EL PASO COUNTY PARKS DEPARTMENT | PARK PLANNING DIVISION

January 14, 2026

Subject: The Triple H Ranch Preliminary Plan (SP-25-004)

MATCH LINE SEE SHEET 4

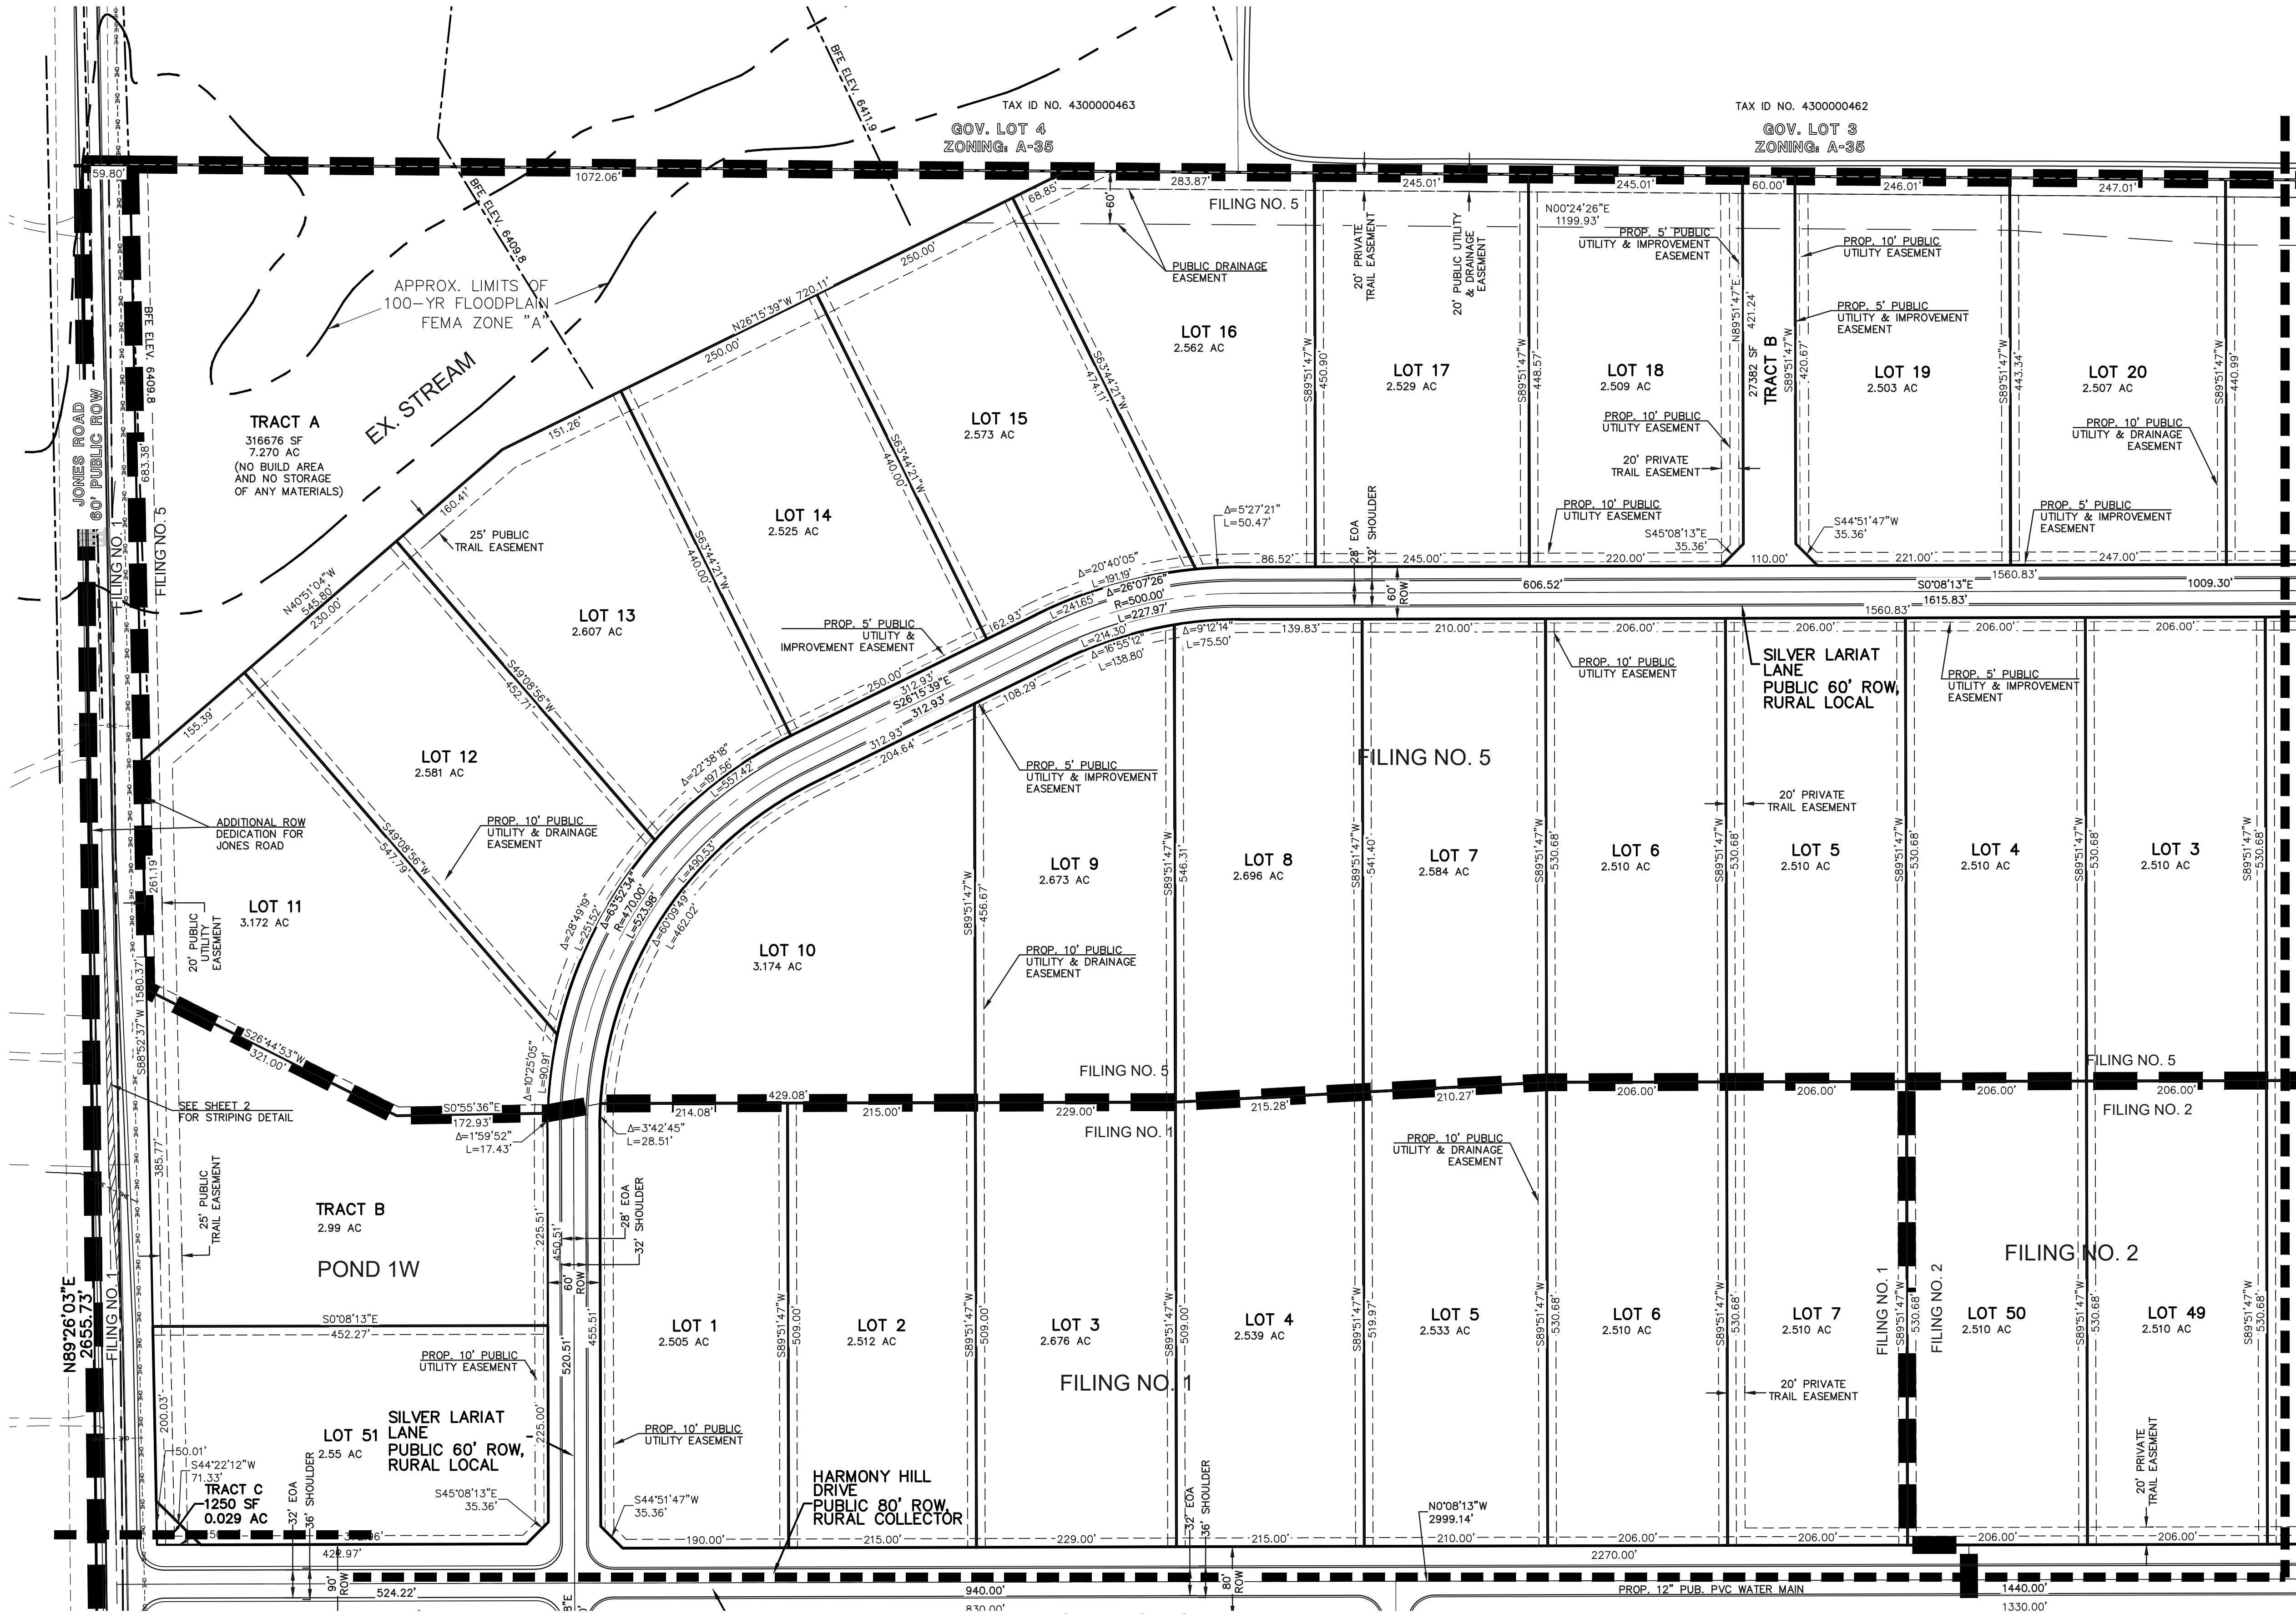
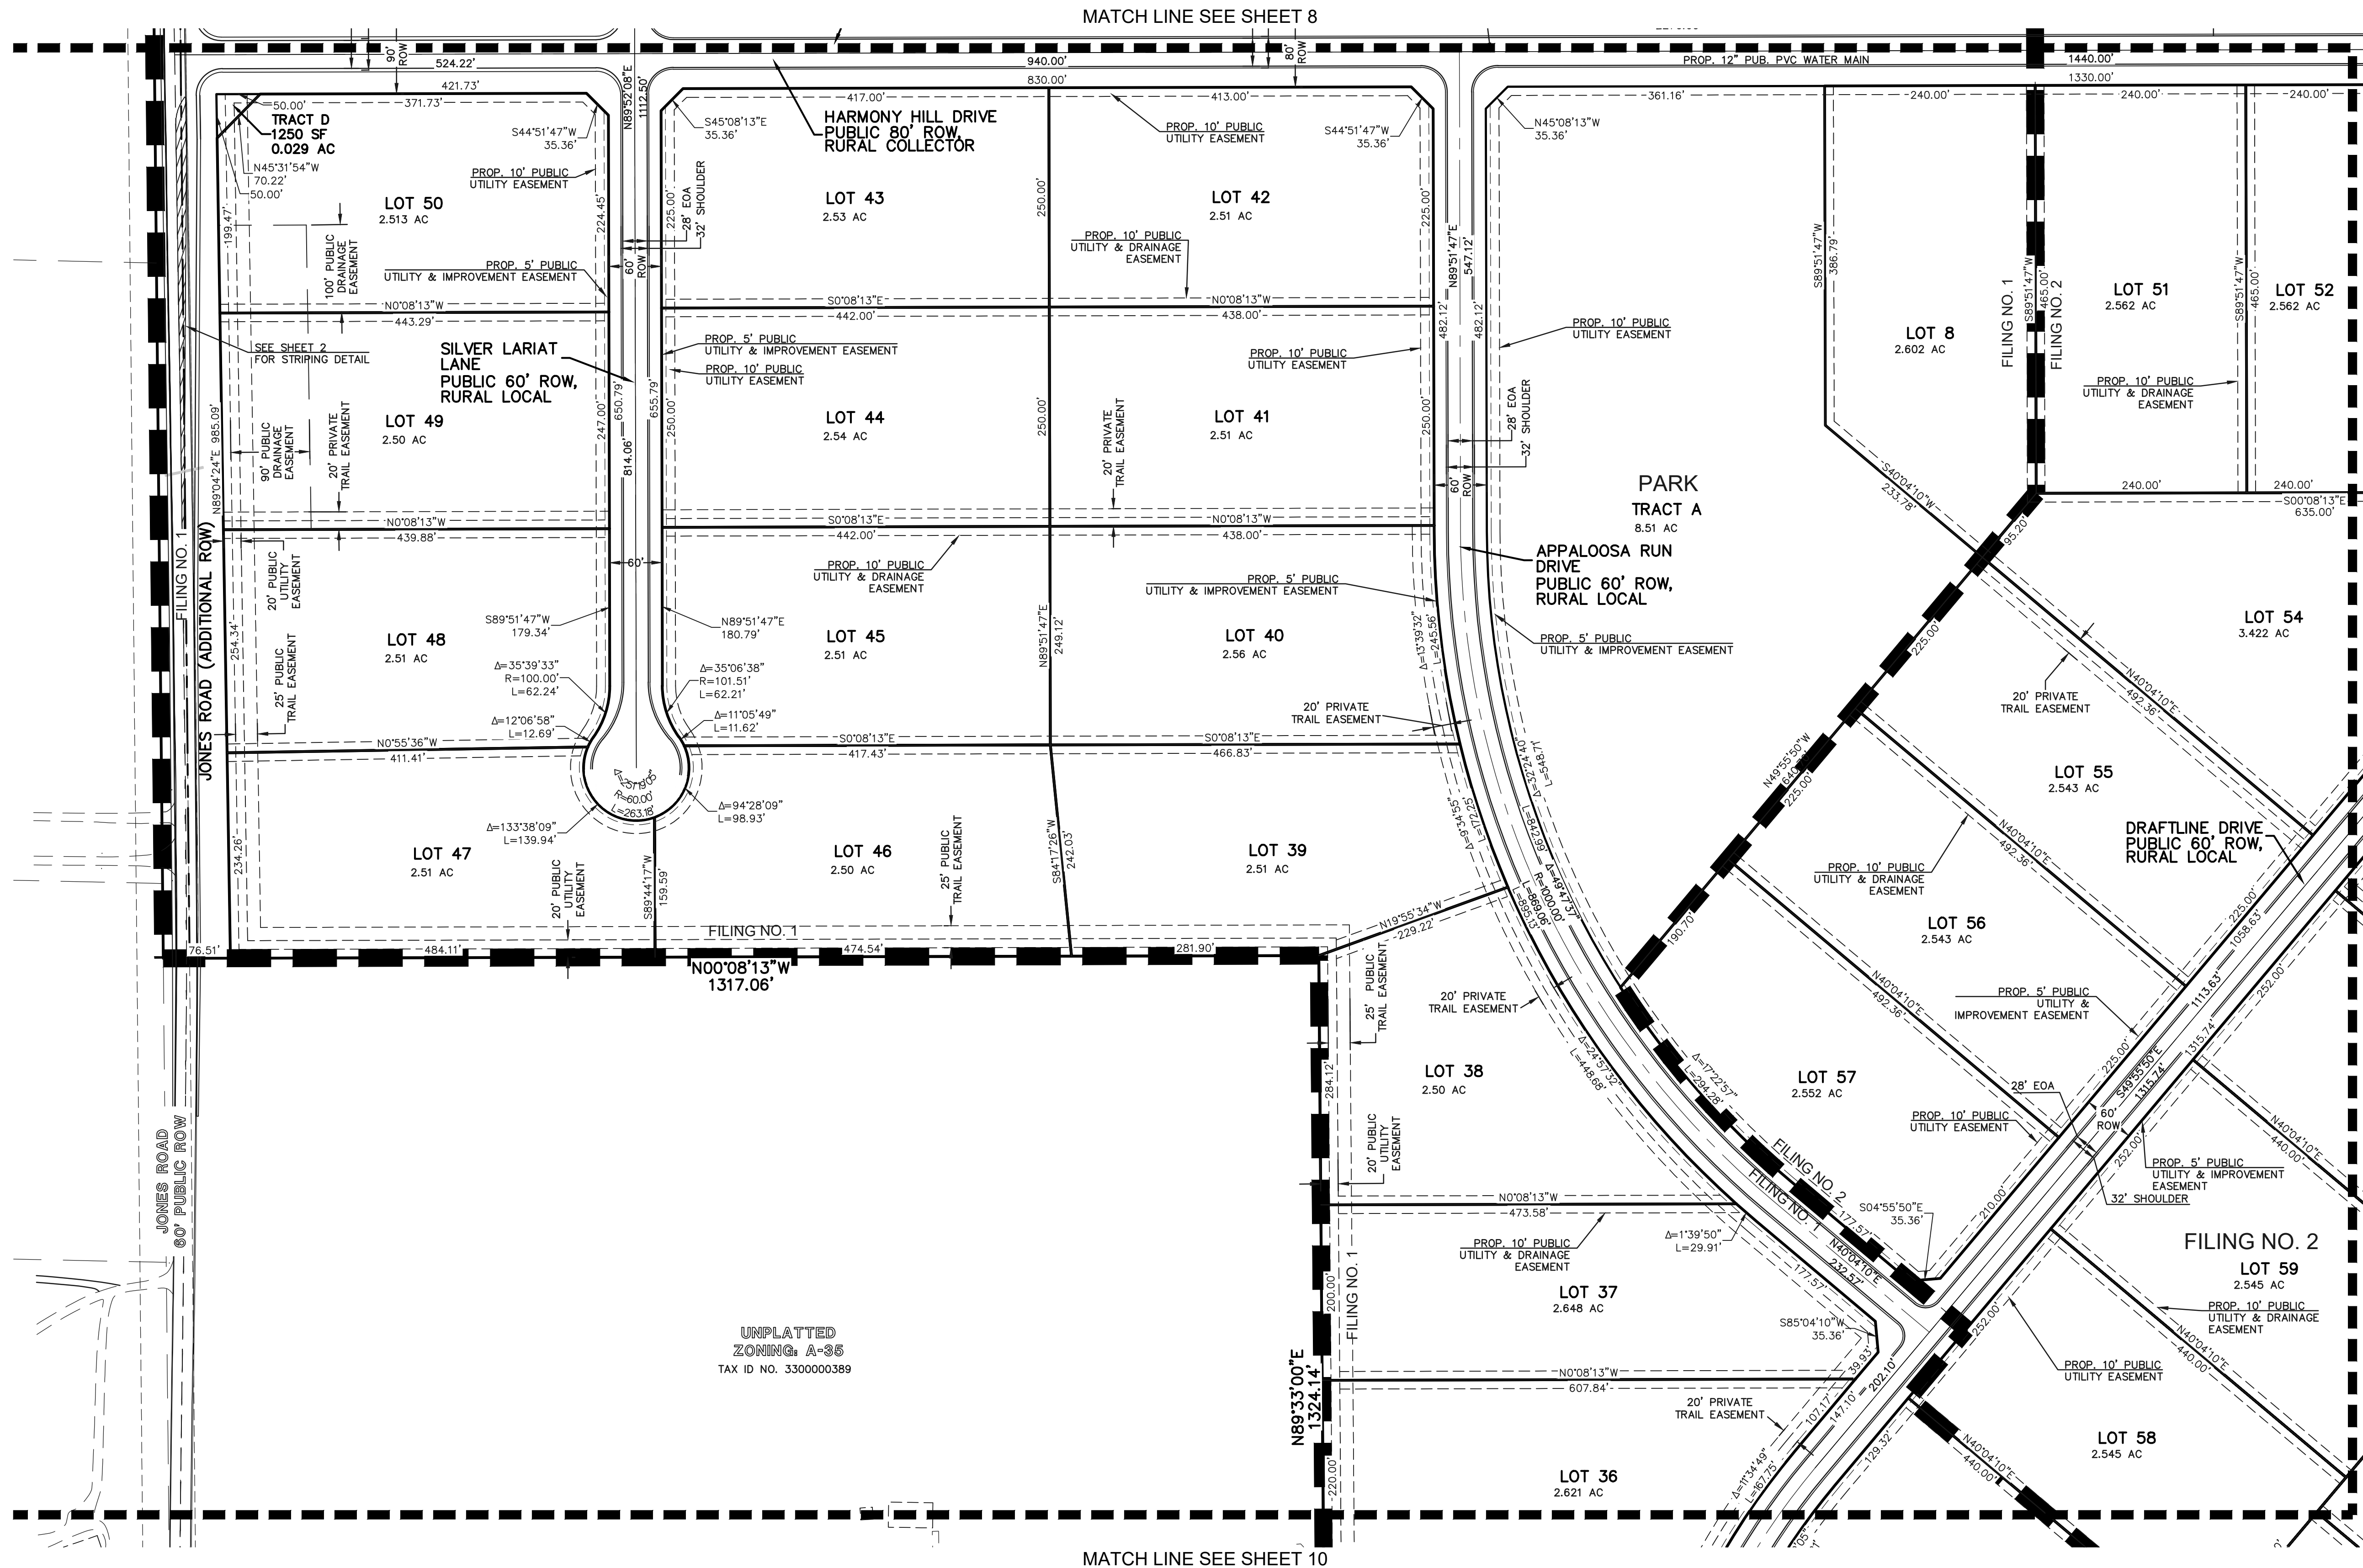
El Paso County Parks staff is pleased to see the applicant's willingness to provide open space tracts, two neighborhood park sites, and trail corridors. Upon review of the preliminary plan drawings, Parks staff noticed that the drawings do not clearly identify proposed county vs. non-county trails. Parks staff is requesting the applicant update and revise the preliminary plan to clearly delineate all trail easements and distinguish between county and non-county trails.

After reviewing the preliminary plan, staff met with the applicant to discuss the regional trail easement corridor along the southern boundary. Specifically, to discuss the alignment of the regional trail around an excluded parcel along Jones Road that would prevent a contiguous trail corridor. After discussion with the applicant, staff is recommending that two trail easements be secured as part of this application, with plat notes stating the County will only develop one alignment and relinquish the other. One easement will follow Jones Road and traverse the southwest corner of the project boundary, following the Parks Master Plan alignment. The second easement would include an alignment within the Triple H project boundary around the excluded parcel, generally along Harmony Hill Road, Appalossa Run Drive, Draftline Drive, and Heritage Hollow Road.

lieu of land dedication for regional park purposes in the amount of \$123,220. A Park Lands Agreement may be an acceptable alternative to required fees, provided the agreement is approved by the County prior to recording the future final plat(s). (2) Designate and provide to El Paso County 25-foot public trail easements along the southwestern boundary and the southern boundary of the Triple H Ranch Preliminary Plan along Jones Road, that allow for public access, as well as construction and maintenance by El Paso County for the Judge Orr Secondary Regional Trail, and the easements be shown, noted, and dedicated to the county via the forthcoming Final Plat(s) (3) Parks staff requests that the applicant designate and provide to El Paso County a 25-foot public trail easement following near Harmony Hill Road, Appaloosa Run Drive, Draftline Drive, and Heritage Hollow Road which are at the south end of the Triple H Ranch Preliminary Plan boundary. Staff recommends that El Paso County relinquish the trail easement if in the future it is no longer required and the master planned proposed trail can be obtained. (4) Parks staff is requesting the applicant update and revise the preliminary plan that clearly delineates all trail easements and explicitly distinguishes between County-maintained and non-County trails.
